**CITY OF ALBUQUERQUE
PLANNING DEPARTMENT
DECEMBER 15, 2004
DRB Comments**

PROJECT # 1003814

RE: Tract H-1, Lands of L. A. Investors/ sketch

DEVELOPMENT REVIEW BOARD--SPEED MEMO

Sketch Plat  
 Proposed Lots H-1-A & H-1-B  
 Lands of Los Angeles Investors  
 Being a Replat of  
 Lot H-1  
 Lands of Los Angeles Investors  
 within  
 Section 14, T.11N., R.3E., N.M.P.M.  
 Albuquerque, Bernalillo County, New Mexico  
 December 2004

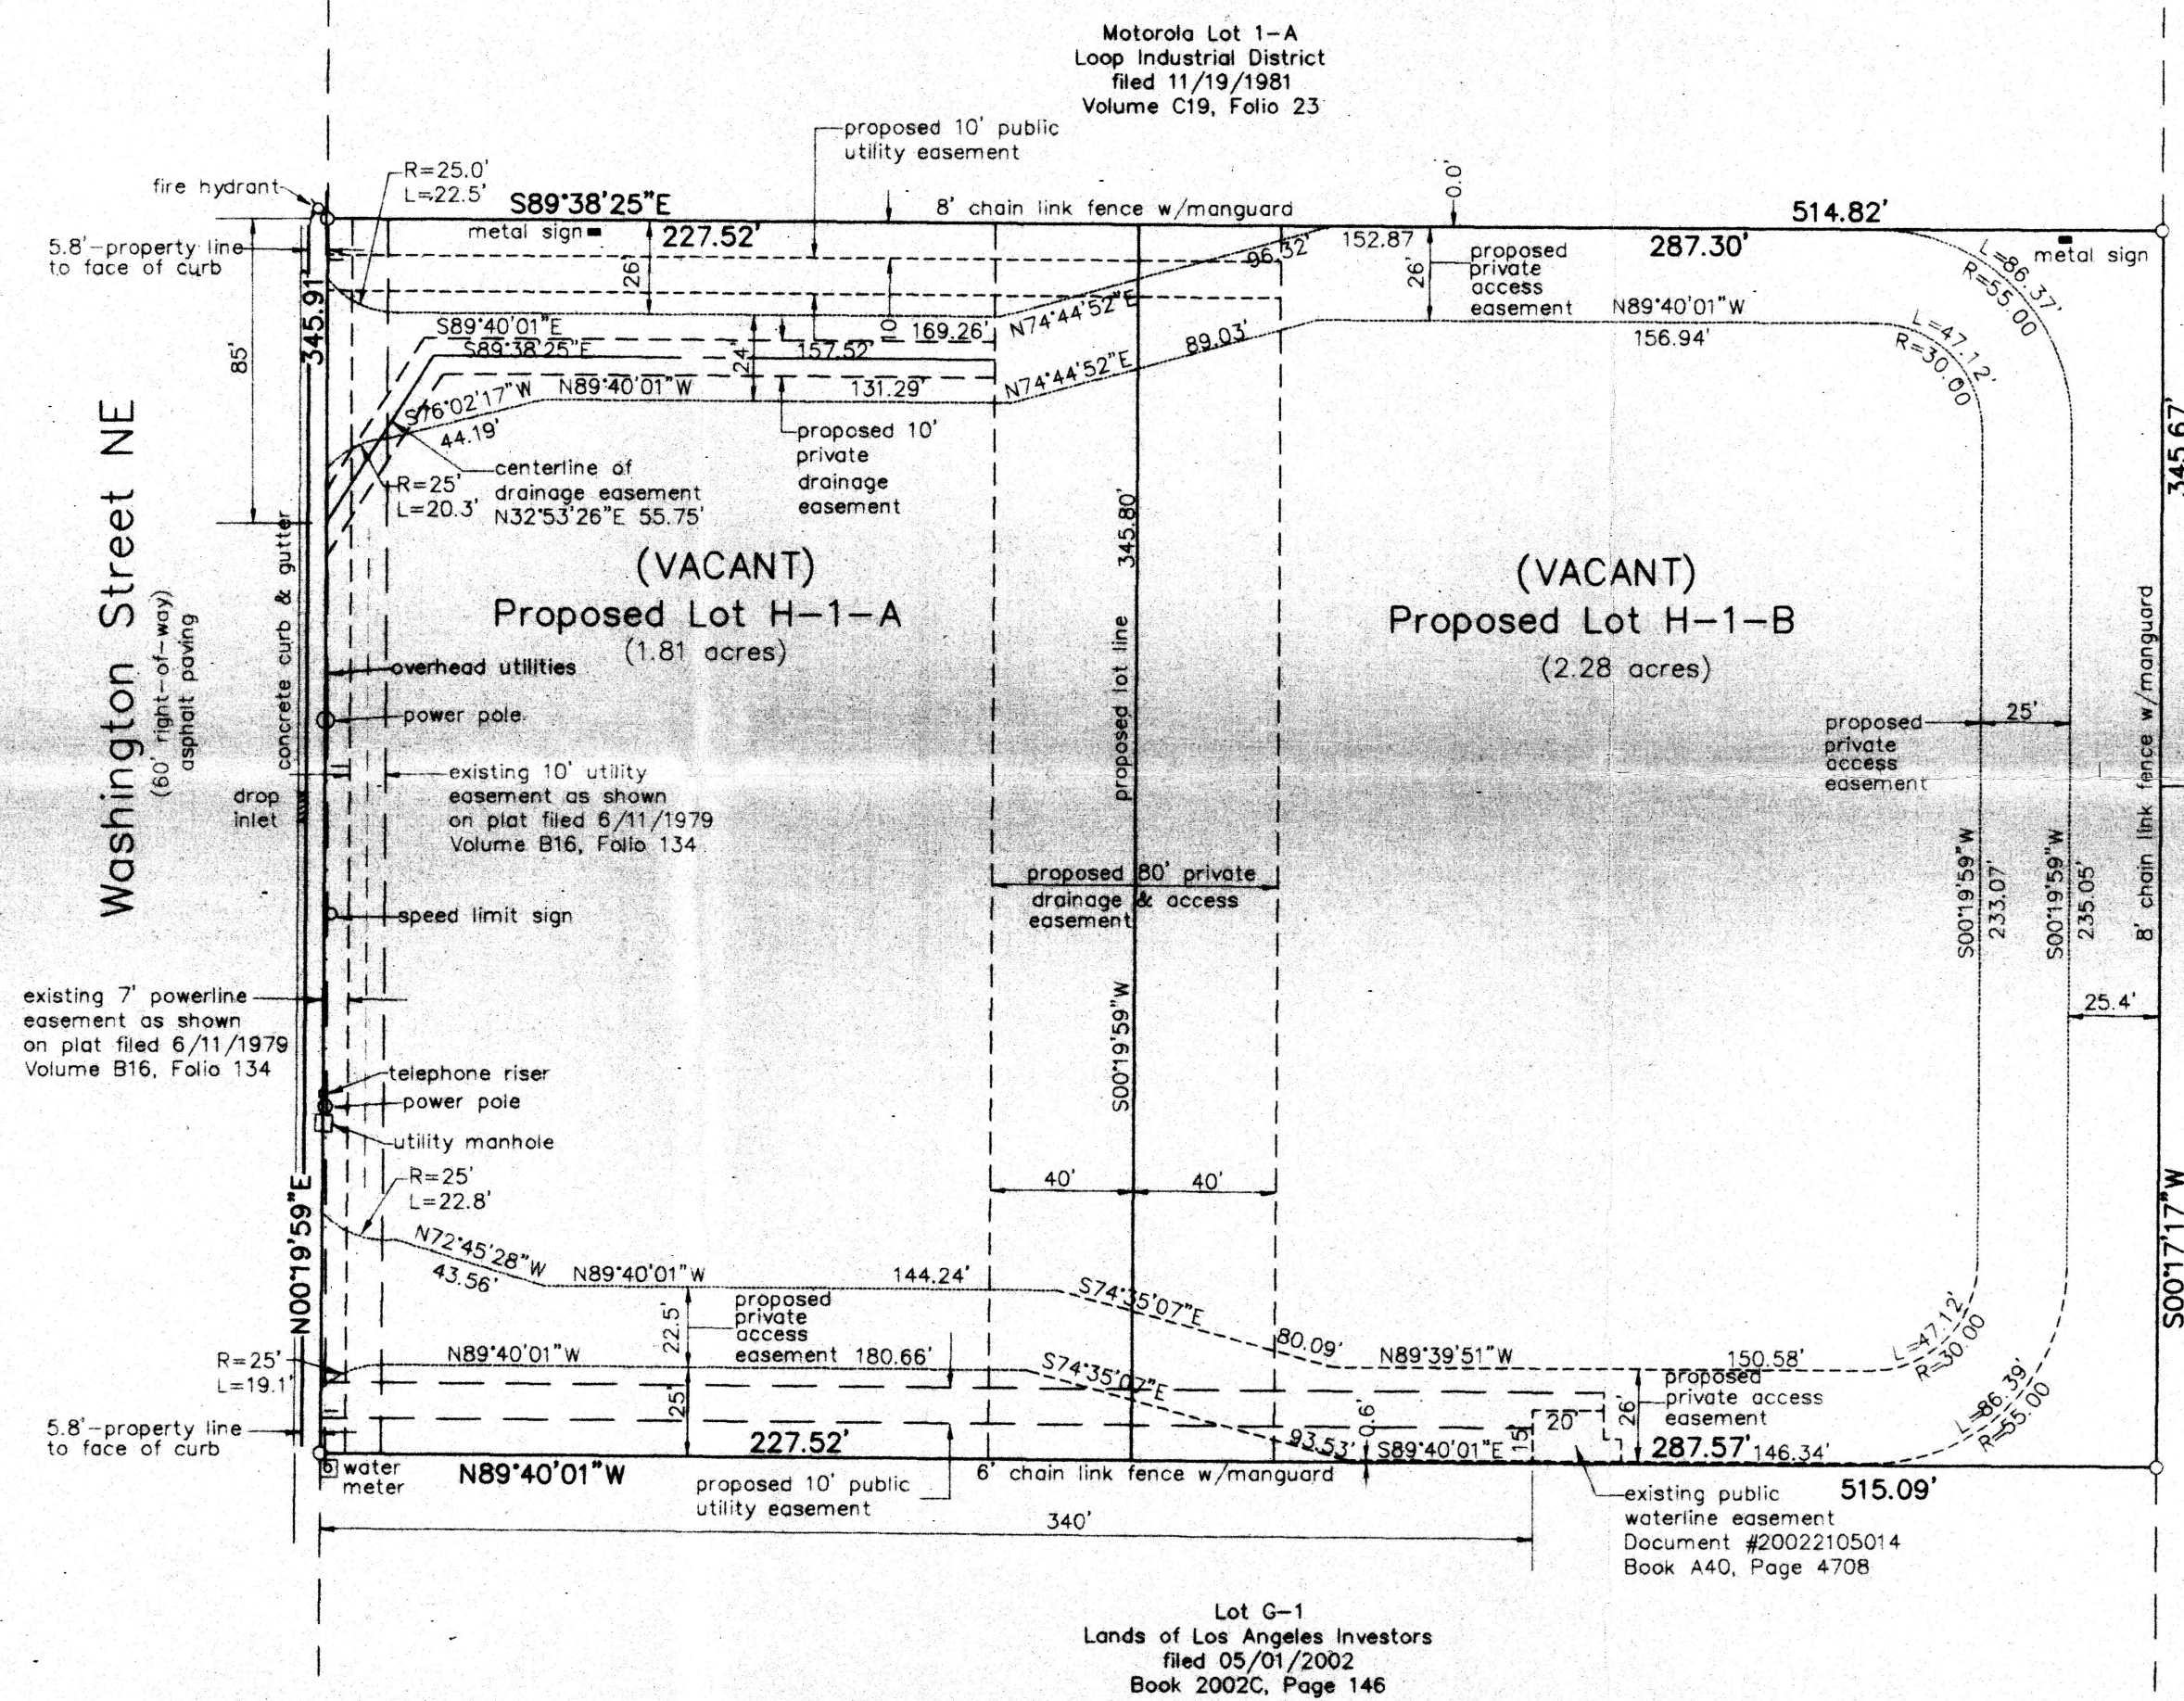
Private easements should state maintenance responsibility and beneficiary.

- 1) Washington street is a paved 4 lane local road. (Sector
New Mexico 87103 Plan) Is the street in place?
2) Is the sidewalk in place?
3) Property line should be 9' from face of curb.
www.cabq.gov 4) Maintenance and beneficiaries of the private easement need
to be listed.
